I write to Object to the above planning application for new toilets and foreshore office on the Promenade as part of the recent re-consultation following changes to the proposals with additional and revised supporting information submitted.

Planning Reference BR/194/17/PL Seafront Toilets and Foreshore Office, Promenade, Bognor Regis

Information further to e-mail dated 11/1/18 objecting to current proposals from Henry Stamp 14/1/18

DRAWING
Proposed Toilet Elevations

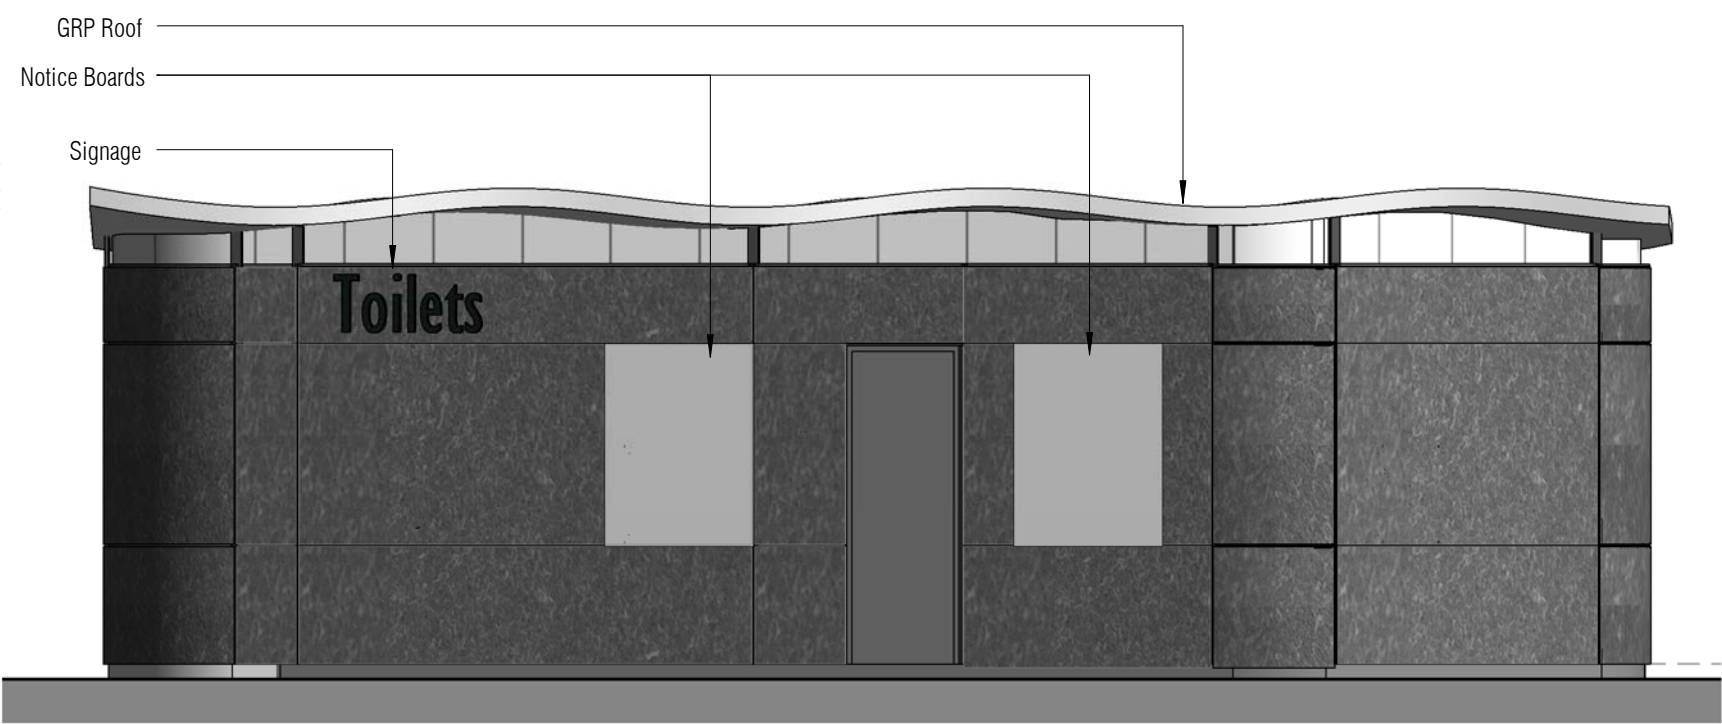
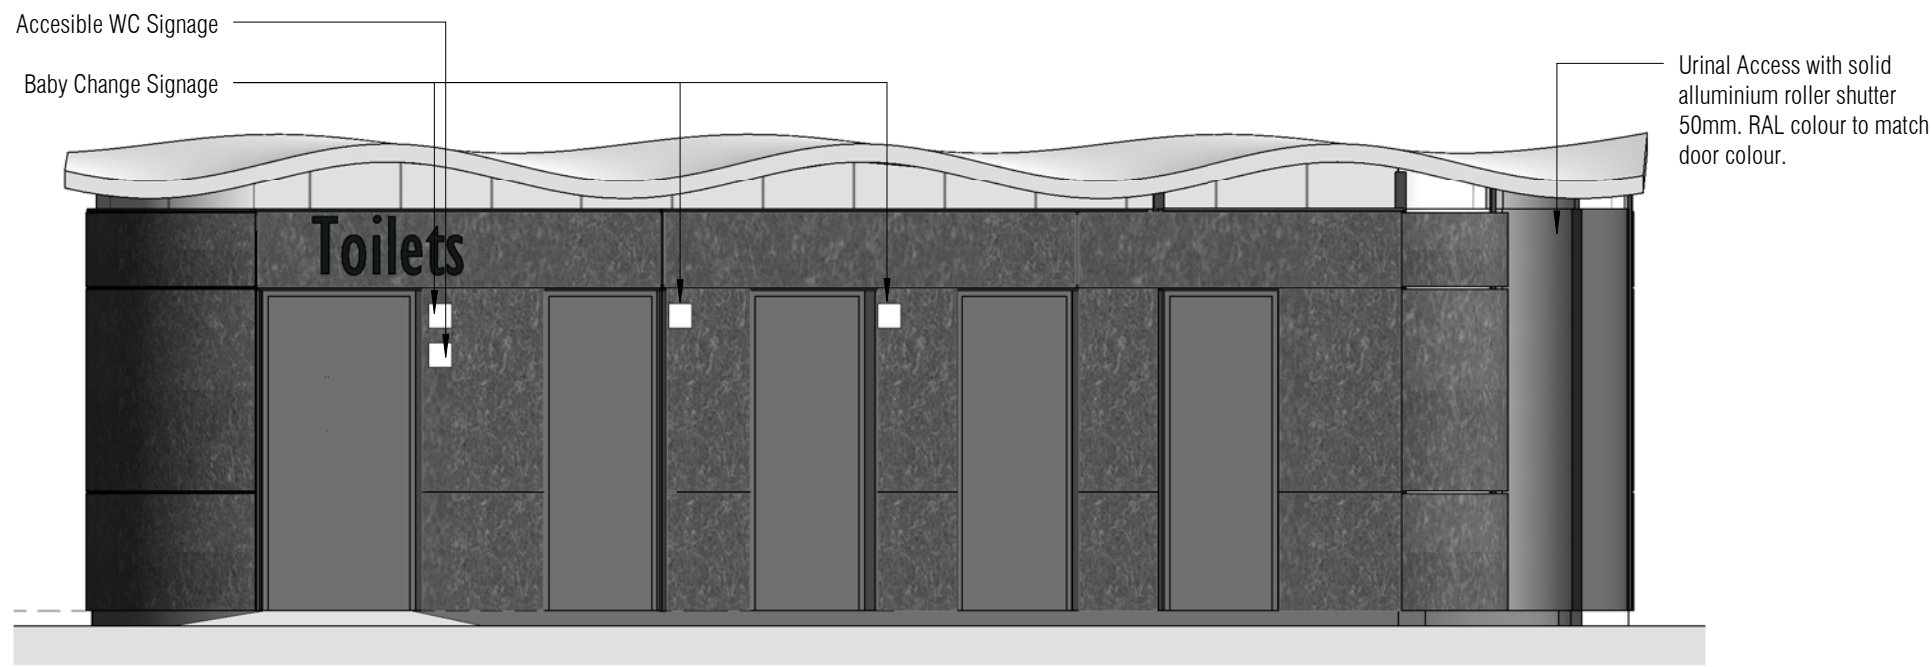
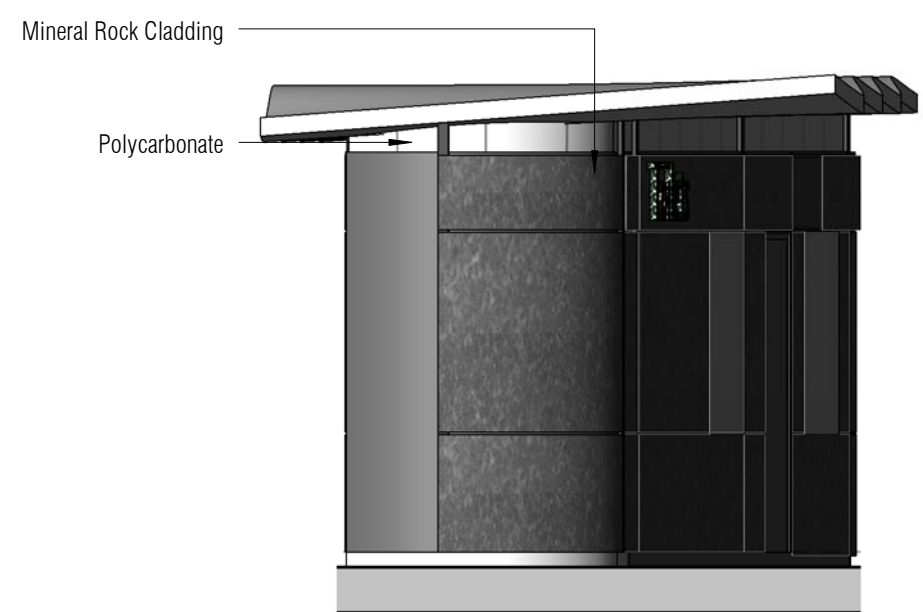
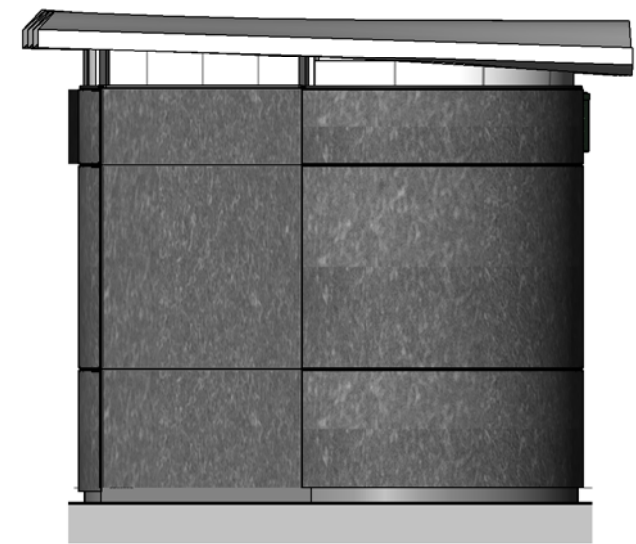
The plans don’t use light and reflective surfaces, which the white render on nearby buildings provides. And the proposals have gone backwards in terms of efficient use of natural resources and reducing energy use: the clerestory glazing, which would have let natural light into the buildings, has been removed as part of recent design changes. This should be put back and natural light into the buildings maximised.

The plans show a roof form that is completely out of character with the site’s context. As some other objections have pointed out, it will be attractive to seagulls perching and roosting; with the mess/’poop’ they make, including over the roof edge onto the Promenade’s surface. This is far less of a problem when roofs have a ridge, where it tends only to be an issue at gable ends. Hipped or gabled roof forms eliminate this end-of-ridge perch and mess near building edges. It would reflect poorly on the applicant if, after completion of the proposed design, anti-bird netting had to be erected over the roofs.

Photomontage from the Promenade

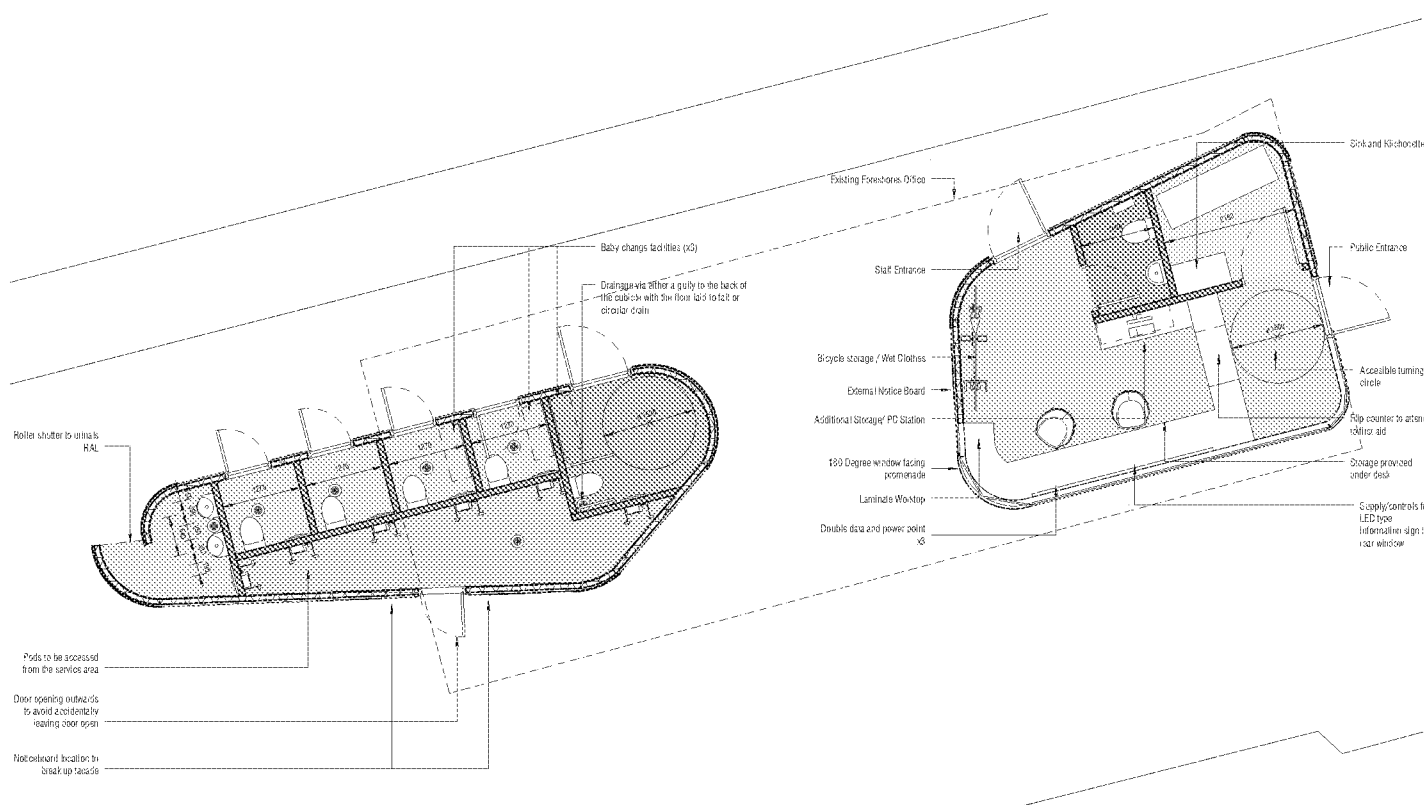
Pages 1 & 7 of the revised DaAS contain a purported "Photomontage from the Promenade", not an artist's impression nor a computer generated image. A photomontage should be a photograph with the proposal superimposed.

However, this supposed photomontage is wrong and misleading/deceptive, as other objectors have spotted: saying it “blatantly attempts to deceive”. The white render, white balconies and the honey coloured stone of the Esplanade Grande building has been ‘photo-shopped’: partly turned to grey and partly faded out so it cannot be seen clearly. This misleading image makes the planned buildings’ grey concrete/mineral cladding panels look less out of place/context and less inappropriate than they will really be. Note that the foreground figures/people haven’t been greyed-out: they have normal coloured clothing. Thus the main context for the proposals is shown misleadingly and cannot be relied upon. Even if the intention was to highlight the planned building (as has been claimed); that doesn’t accord with either the photomontage’s caption or the purpose of a DaAS. The photomontage on page 7 does not show, as Space & Place architects claim, “how the buildings will sit on the site”: the site is not correctly shown!
